REQUEST

Current Zoning: MX-3 (Mixed-Use, conditional)
Proposed Zoning: N2-A(CD) (Neighborhood 2-A, conditional)

Approximately 27.82 acres located east of Old Statesville Road, south of West W.T. Harris Boulevard, and west of Old Potters Road.

The petition proposes the development of up to 113 multi-family attached dwelling units. The site is currently undeveloped.

RZ-2

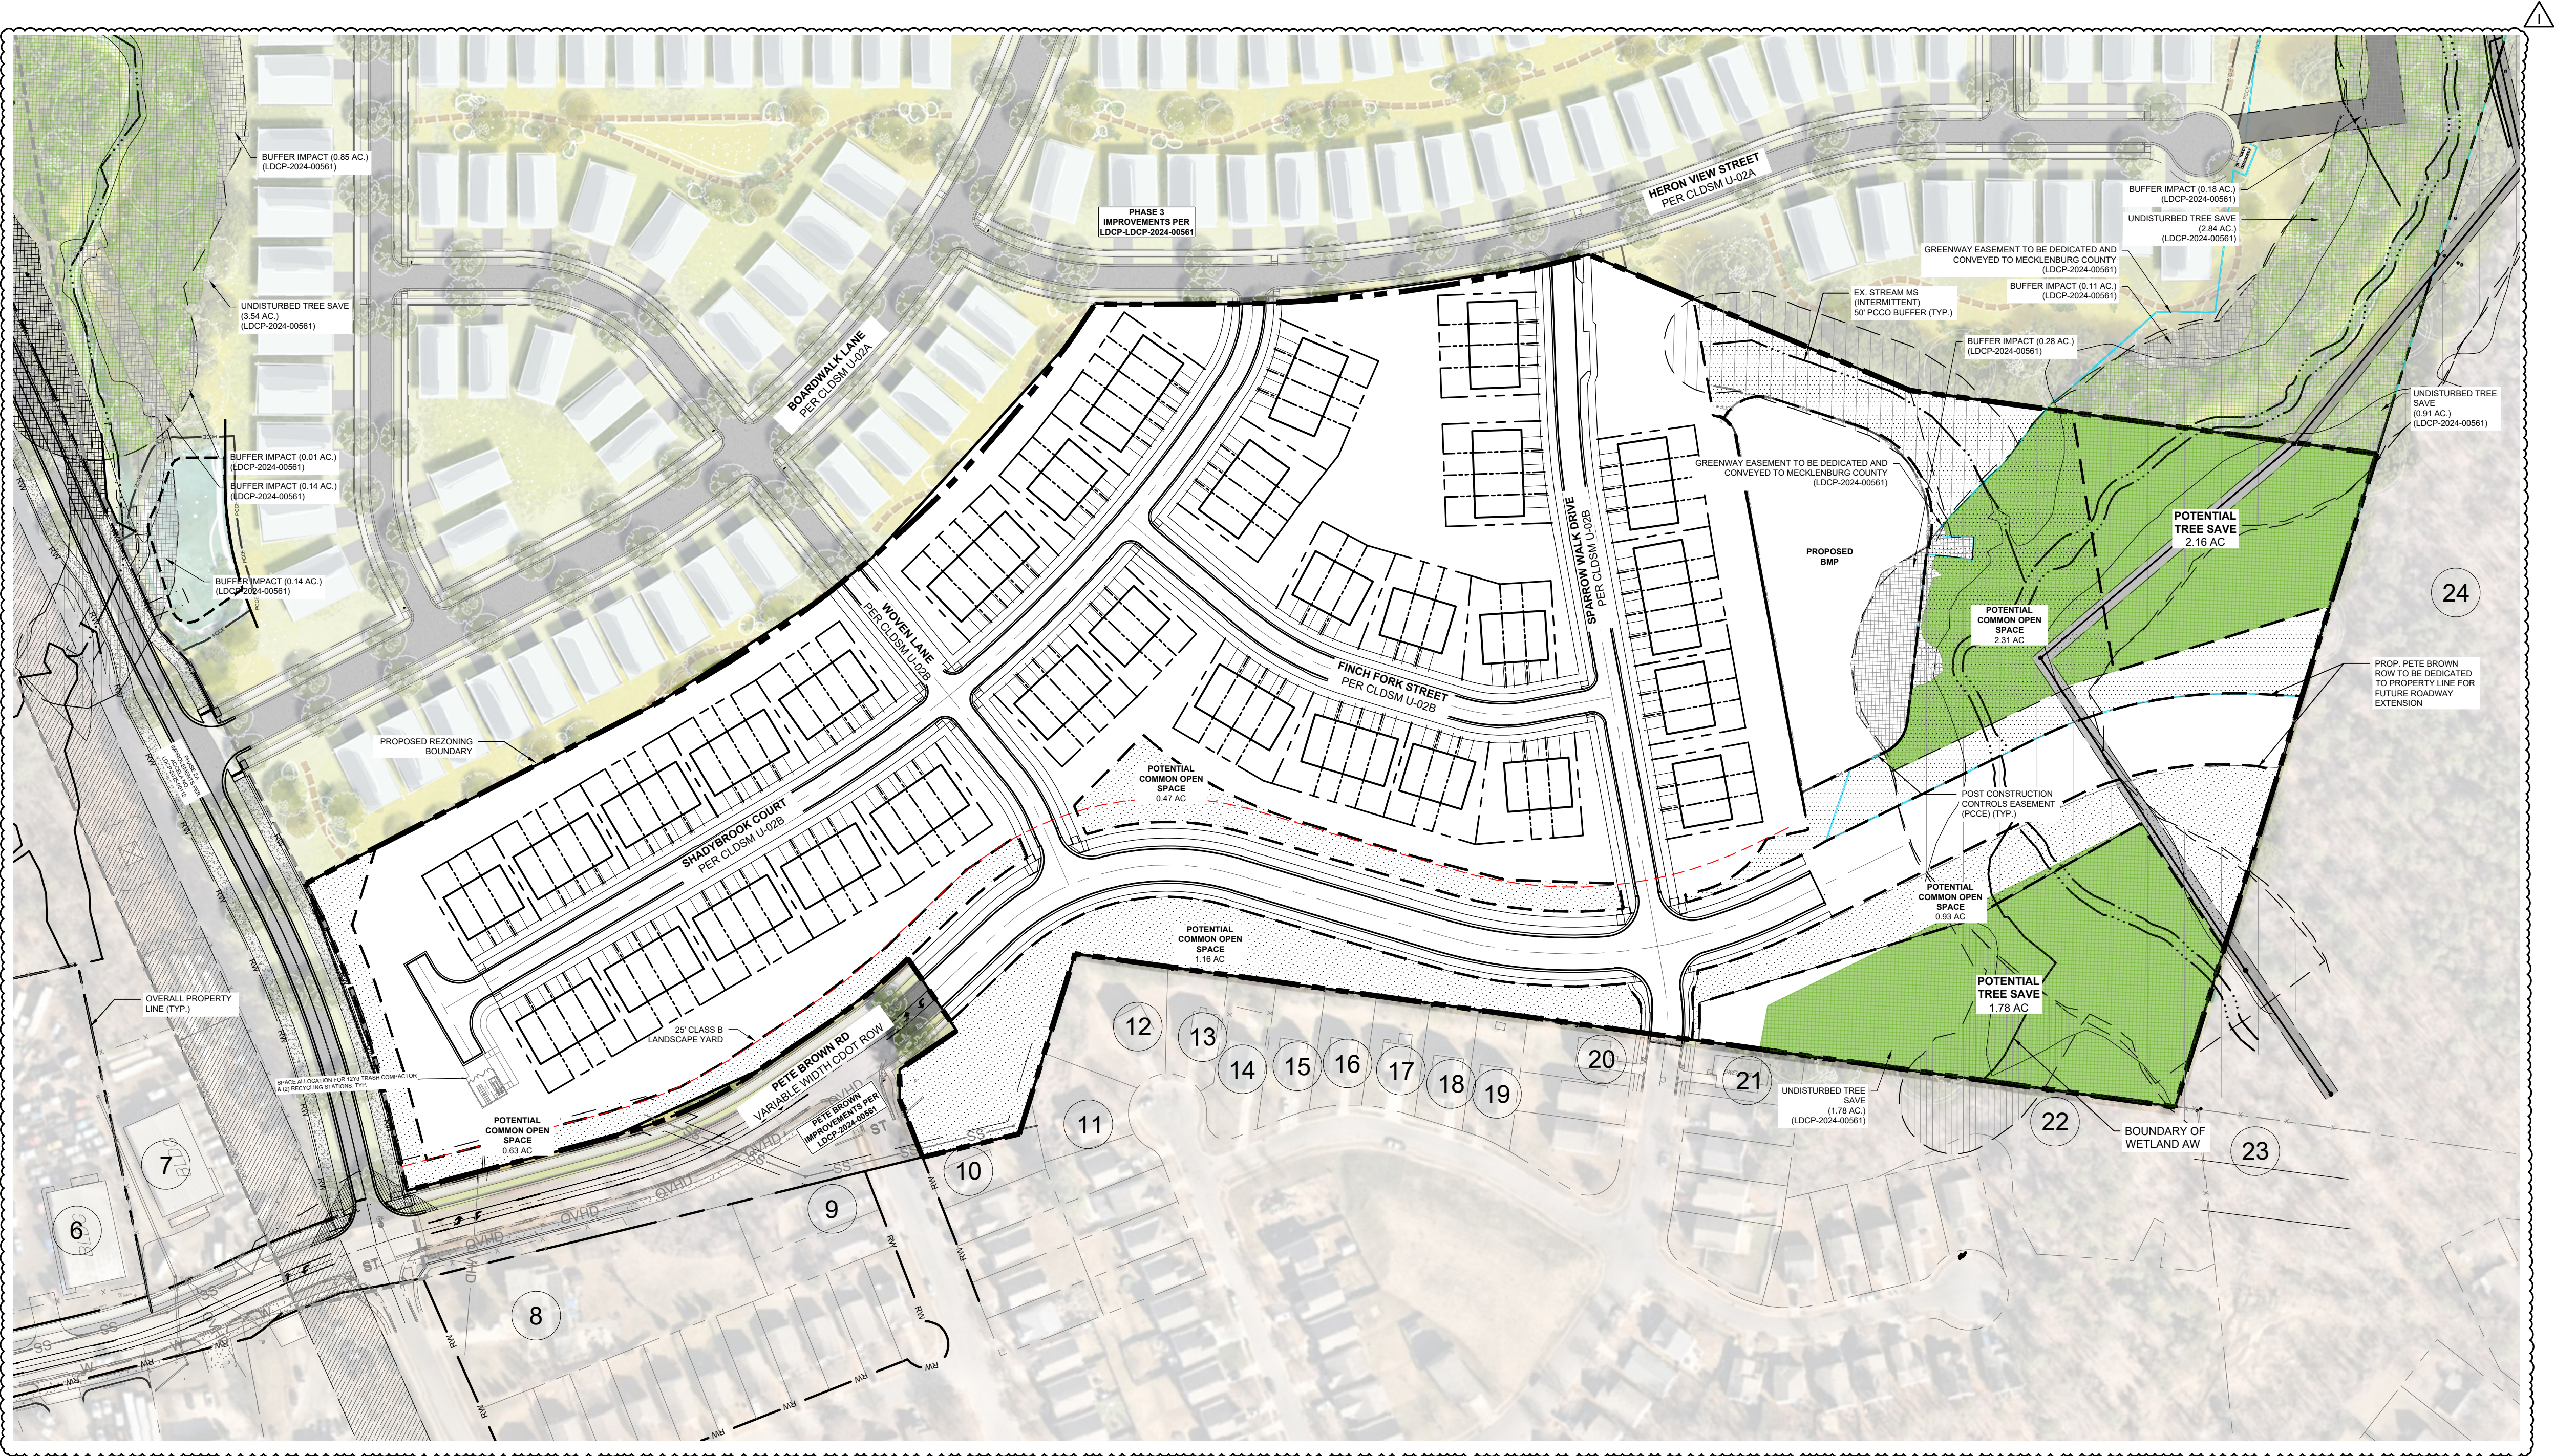
1. ~~CDOT: Revise site plan and conditional notes to construct 8' sidewalks along all internal roads per UDO and CLDSM U-02B. Revise site plan and conditional note(s) to reflect this requirement.~~
Addressed

2. ~~Park and Recreation: label the greenway easement shown outlined in blue within the rezoning boundary.~~ Addressed
